Thank you for the opportunity to comment on the Marzlof-Kelley Short Plat, SP-08-01. Pursuant to the Memorandum of Agreement between Kittitas County and the Washington State Department of Ecology all residential well connections serving the proposed lots shall be required to have meters installed. Metering results shall be recorded in a manner consistent with Kittitas County and Washington State Department of Ecology requirements. The requirement to meter only applies if you rely upon the RCW 90.44.050 exemption from permitting through ecology.

TO: Scott Turnbull, Community Development Services  
FROM: Christina Wollman, Planner II CW  
DATE: February 2, 2009  
SUBJECT: Marzolf-Kelley Short Plat SP-08-01

Subject: SP-07-xx; Marzolf – Kelley Short Plat; 4-Lot Short Plat  
SR 970, MP 5.75 Left.

DWN BY S. TAYLOR	DATE 12/07	JOB NO. 07268
CHKD BY D. NELSON	SCALE 1"=200'	SHEET 1 OF 4

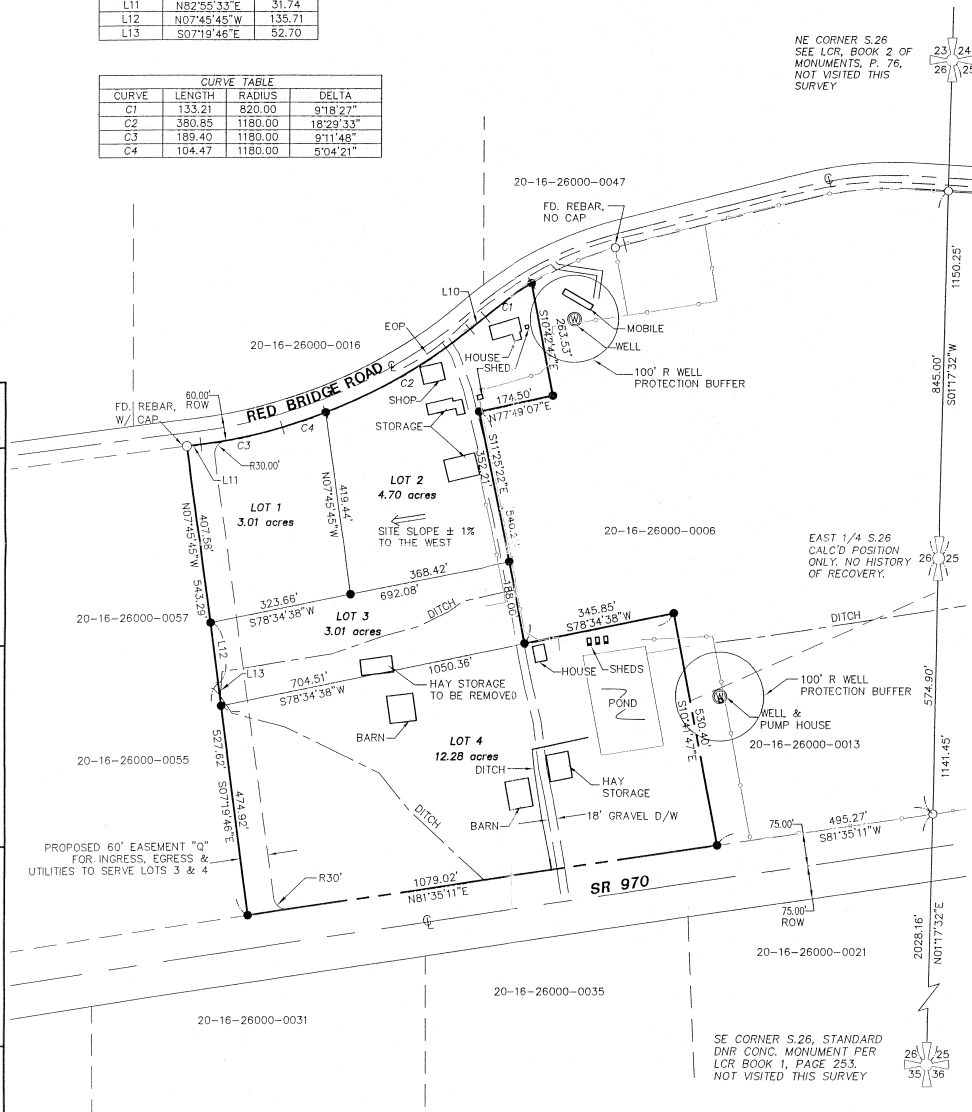
2. **SR 970 Access:** Per WSDOT, no access shall be allowed to SR 970 and the existing access to SR 970 shall be removed.
3. **Easement 'Q':** All access to Lots 1, 3, and 4 shall be from Easement 'Q'. A cul-de-sac shall be constructed at the end of the easement. The cul-de-sac may be temporary to accommodate future development.

1. The subject property is adjacent to State Highway 970. SR 970 is a Class 1 access managed highway in this area with a posted speed limit of 60 miles per hour. No direct access for any of the proposed lots will be allowed to SR 970 per WAC 468-52-040 (1). We request the following:

- Verbage be placed on the plat near the existing access to SR 970 that states that the existing access to SR 970 be removed.
  - A note be placed on the plat that states that no direct access to SR 970 will be allowed from this short plat.

- That the 60' easement for ingress, egress, and utilities from Red Bridge Road be terminated at the boundary between lot 3 and lot 4.
2. SR 970 is an existing facility. The proponent should be aware that they are proposing development in an area with traffic noise. They should also expect that traffic noise may continue to grow into the future, and, as an essential public facility, may need to be expanded to accommodate future traffic growth. If the proponent is concerned with traffic noise affecting this development, it is the developer's responsibility to dampen or deflect any traffic noise for it.
